REQUEST

Current Zoning: N1-A (Neighborhood 1-A)
Proposed Zoning: N2-A(CD) (Neighborhood 2-A, Conditional)

Approximately 32.35 acres located east of Trevi Village Boulevard, south of North Tryon Street, and west of Hudspeth Road.

The petition proposes the development of up to 190 multi-family attached dwelling units. The site is currently developed with 2 single-family houses.

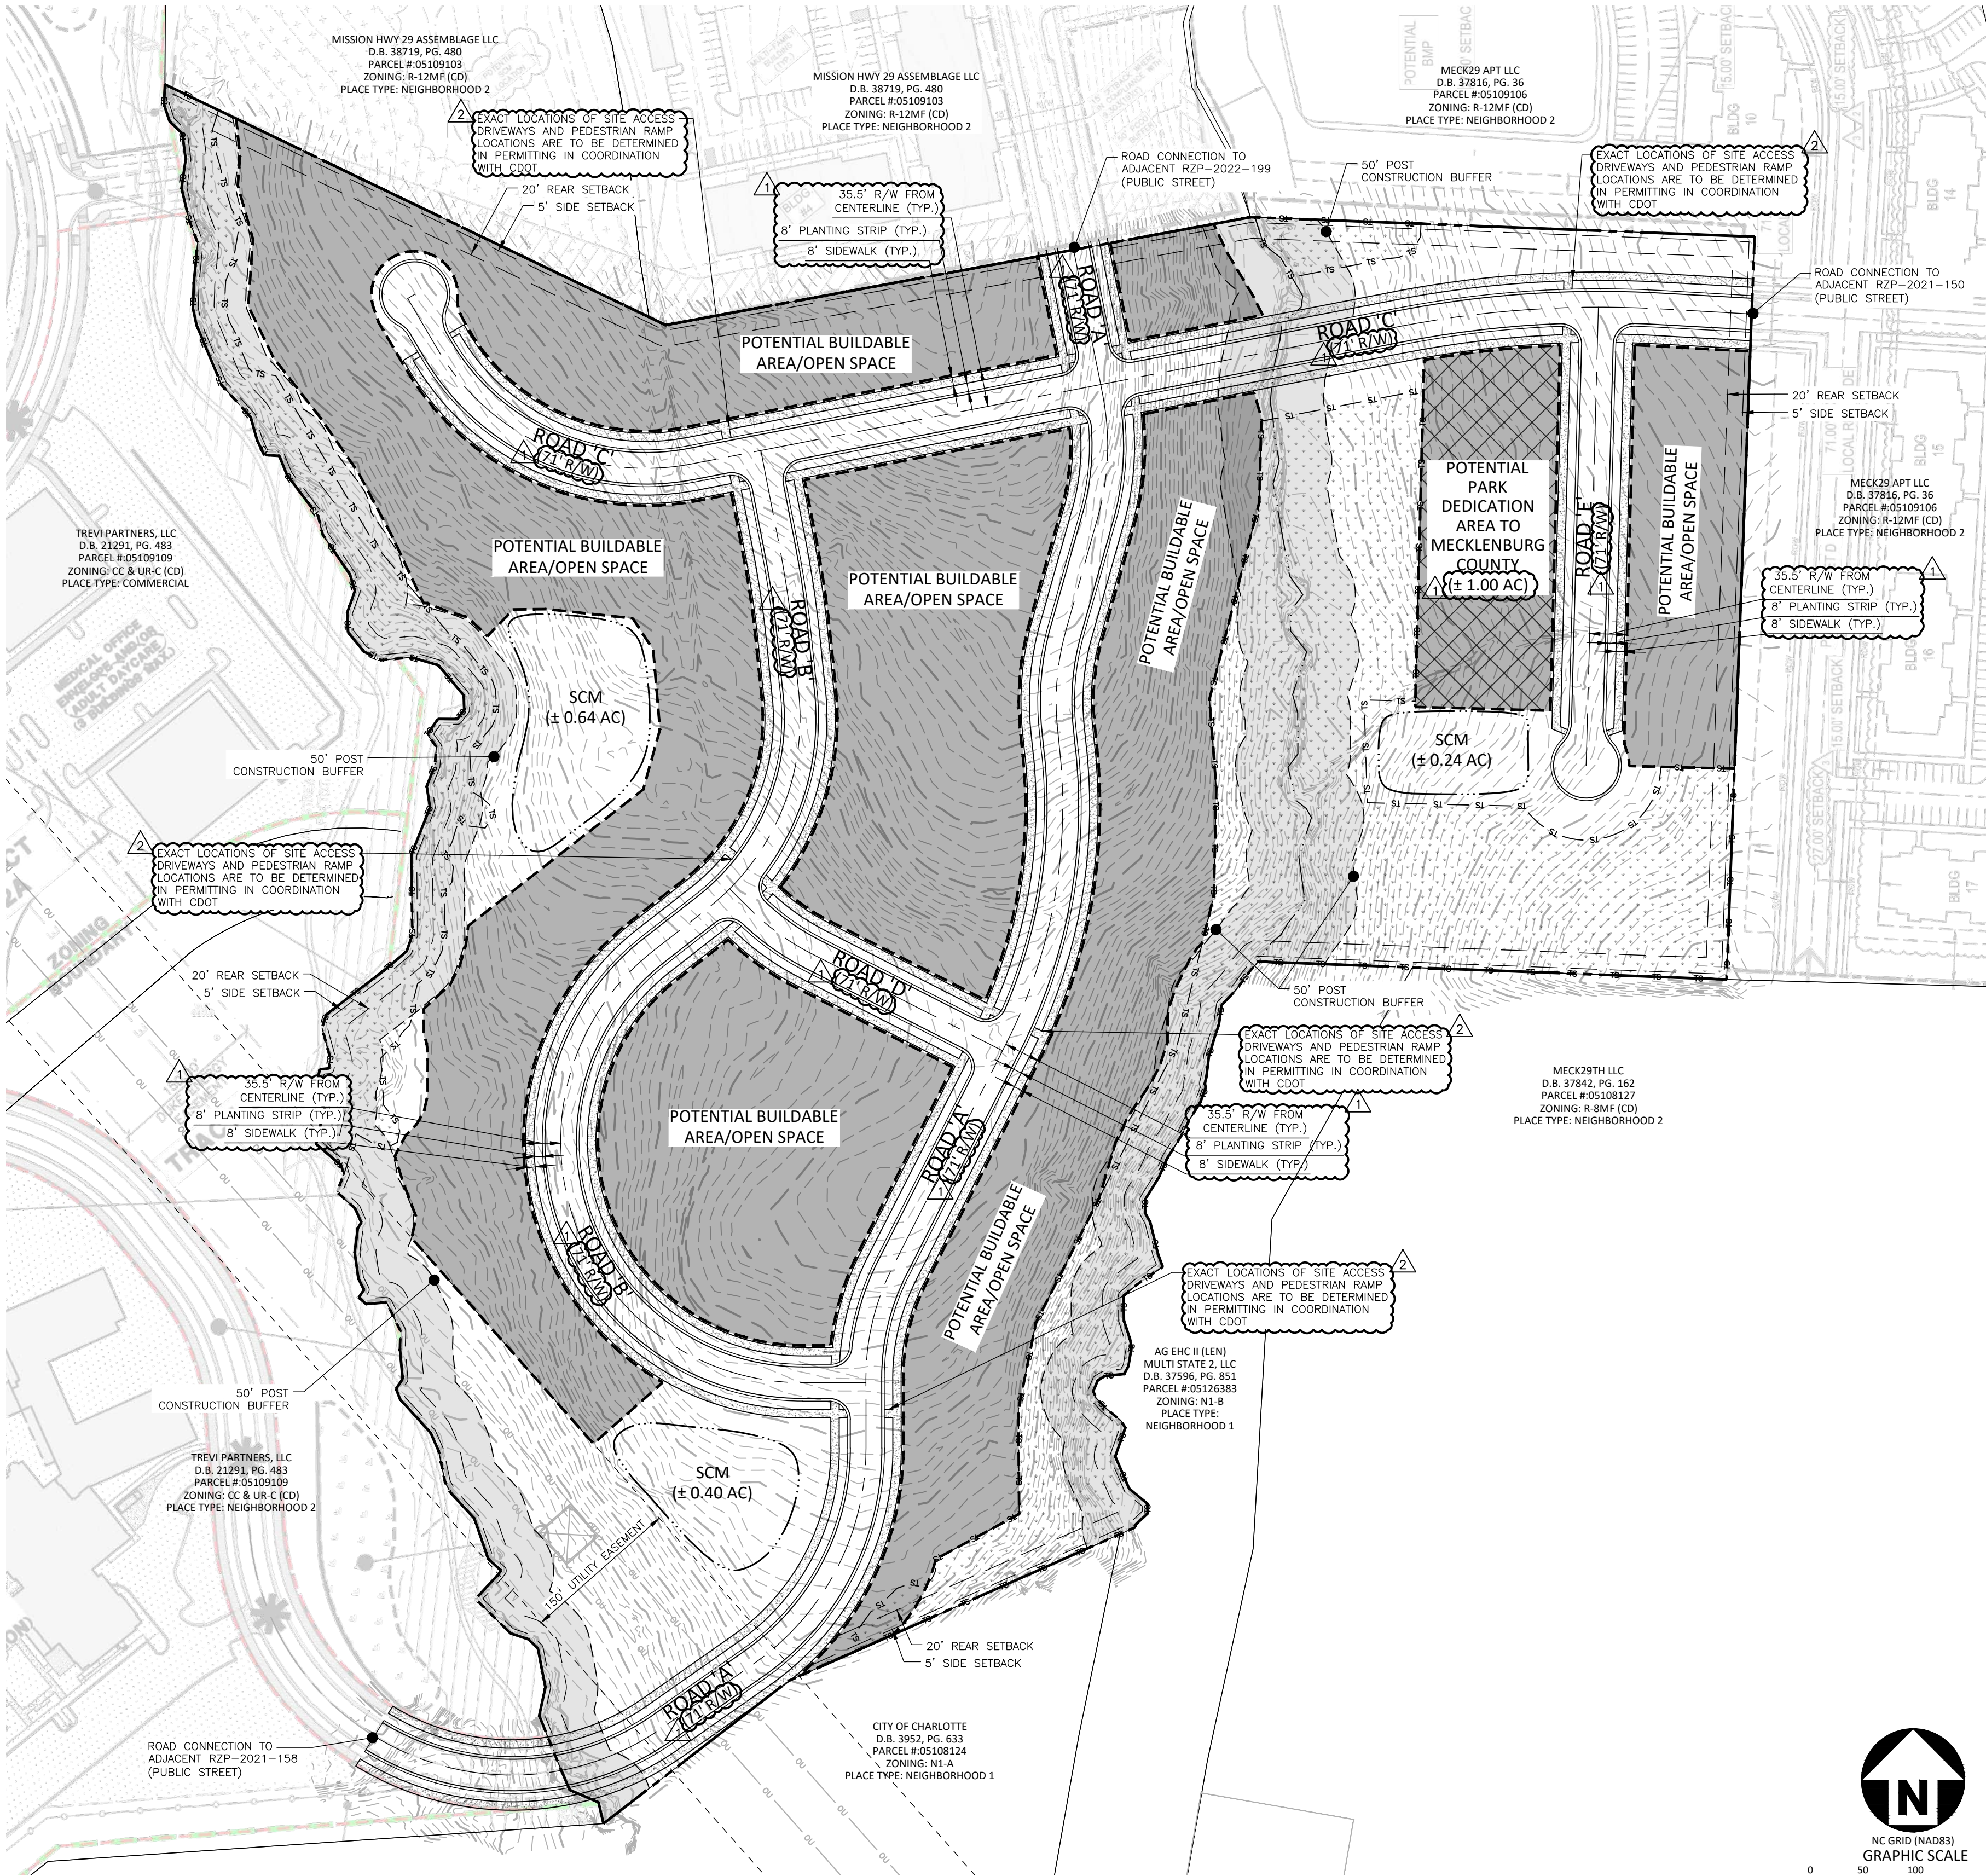
1. ~~Show additional ramps at the intersections within the site plan.~~ Addressed
2. ~~Revise site plan and conditional note(s) to commit to a roadway stub to St. Margarets Way in coordination with subdivision. Site plan shall label and dimension from roadway centerline.~~ Addressed

TREE SURVEY

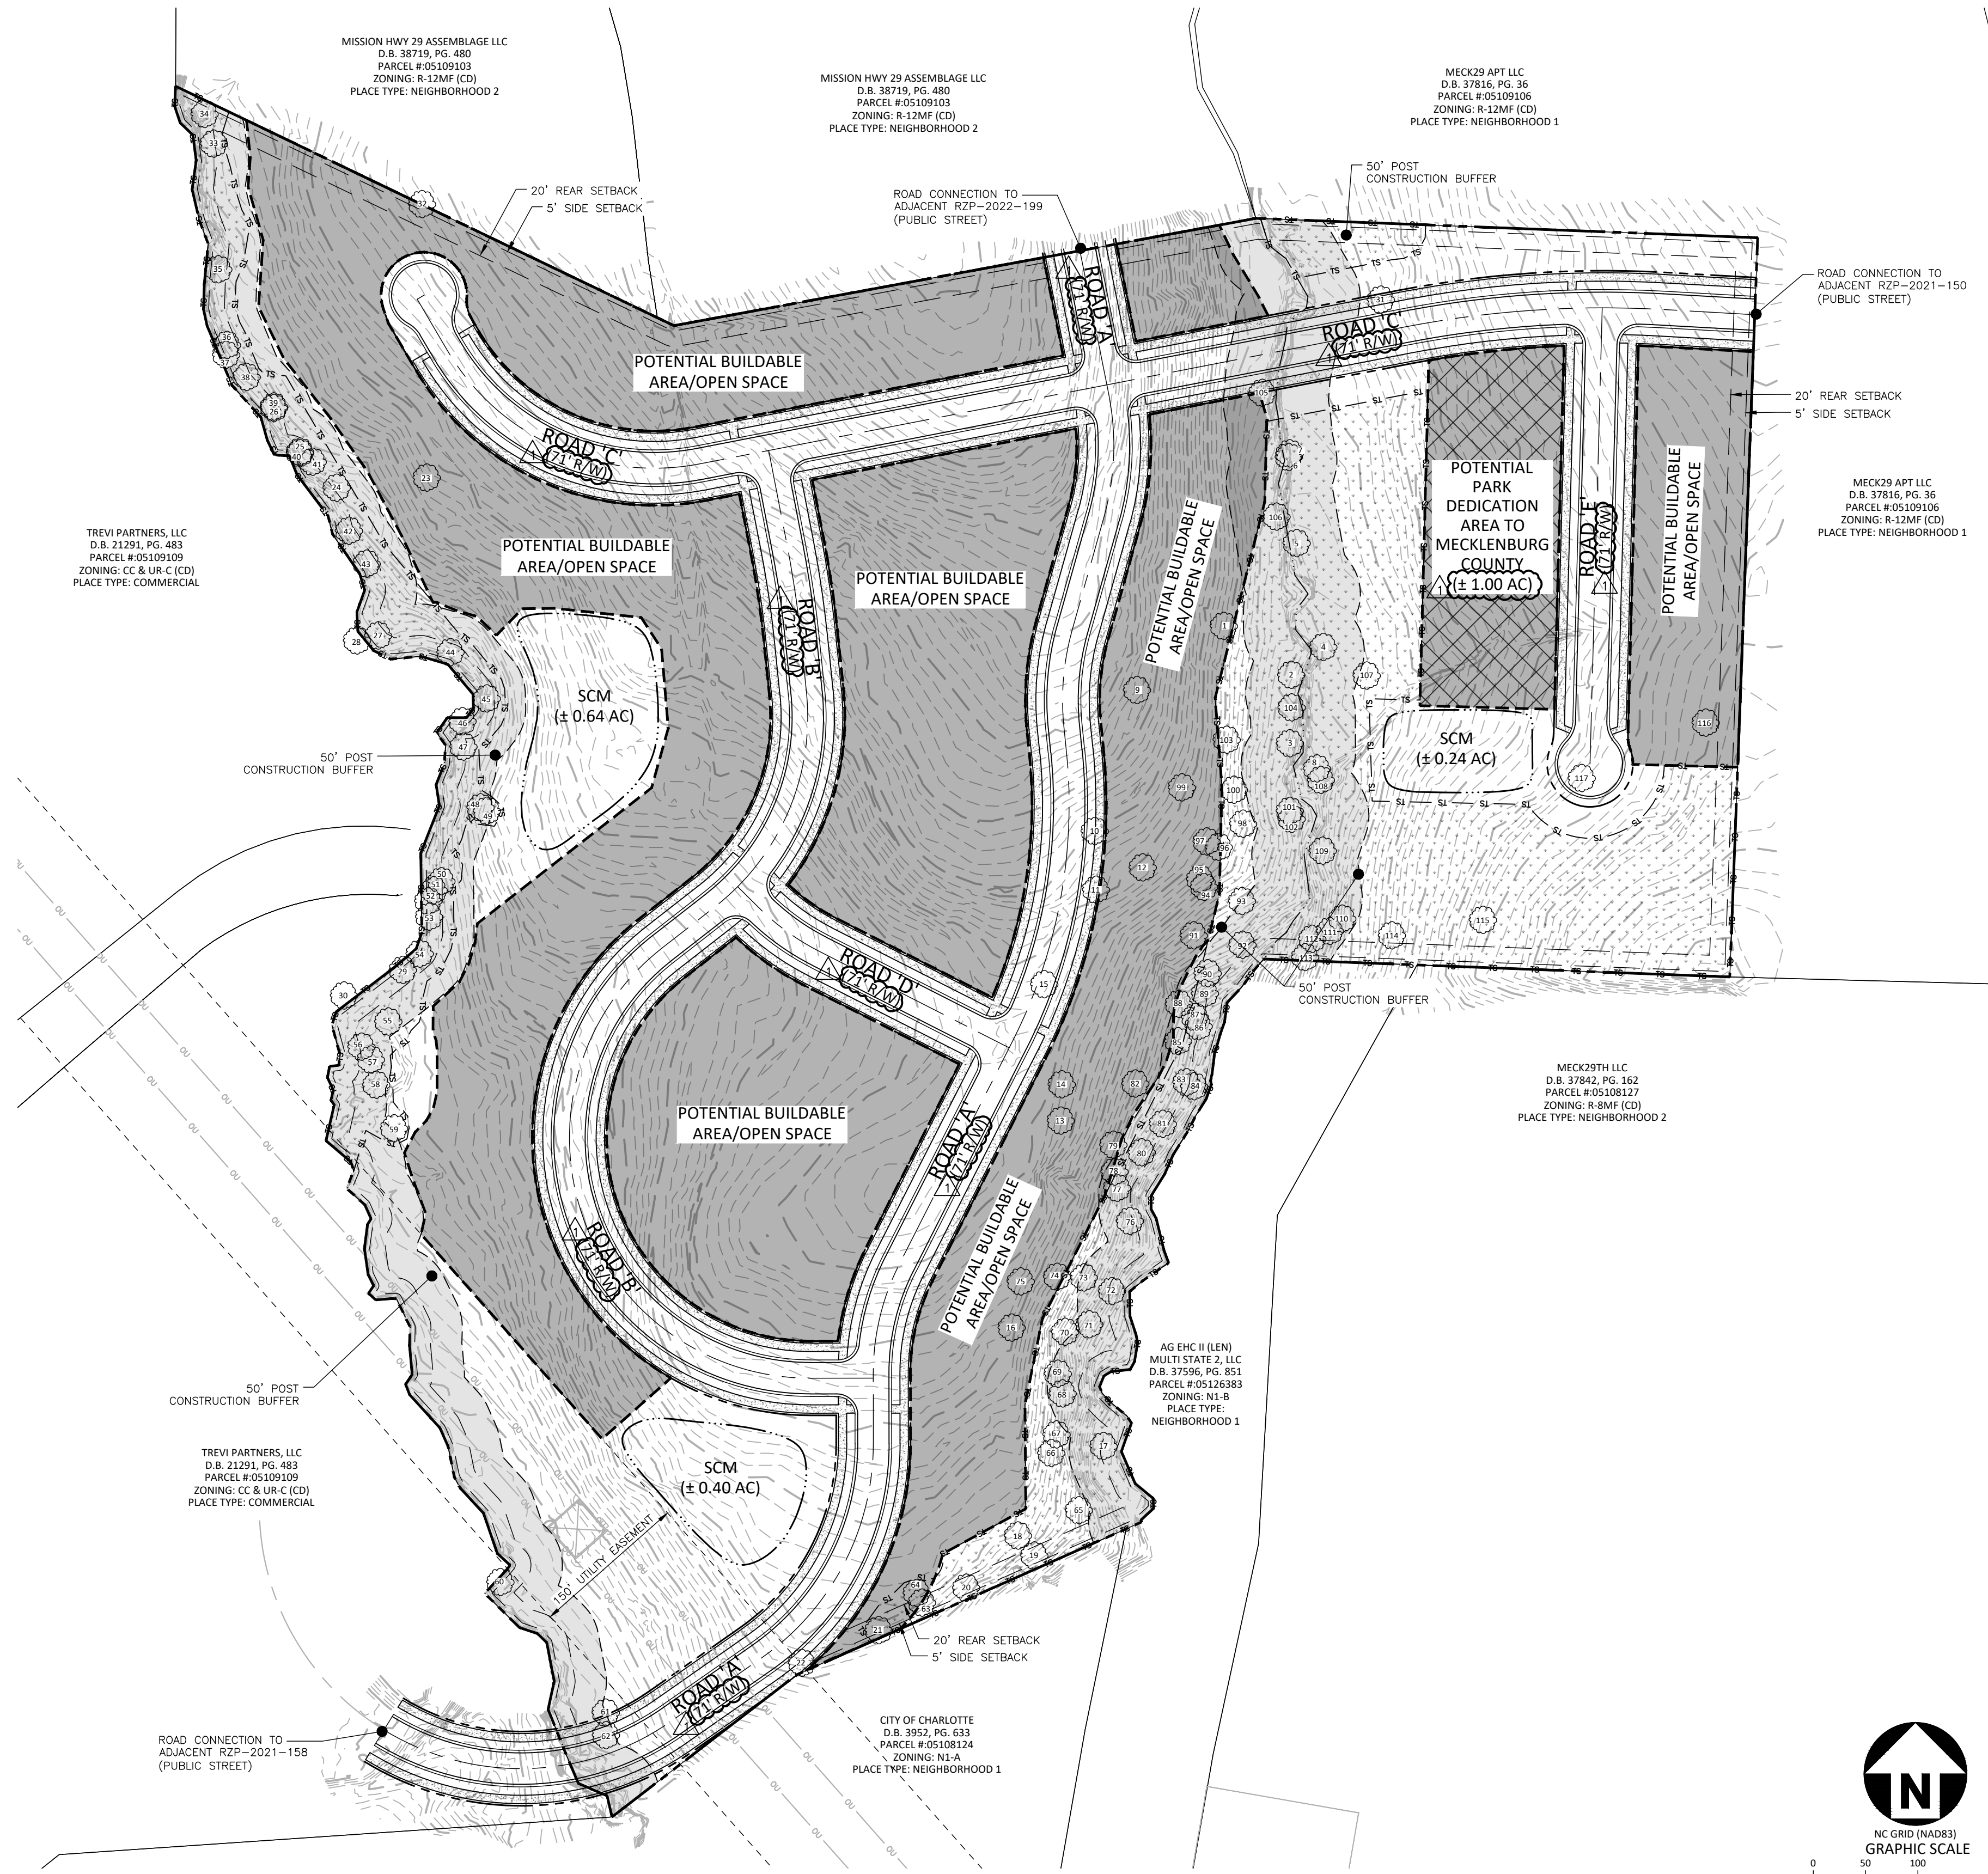
3. The boundary/tree save line does not match the property line. Accurately show the property line.
4. ~~Define and quantify enhanced plantings.~~ Addressed
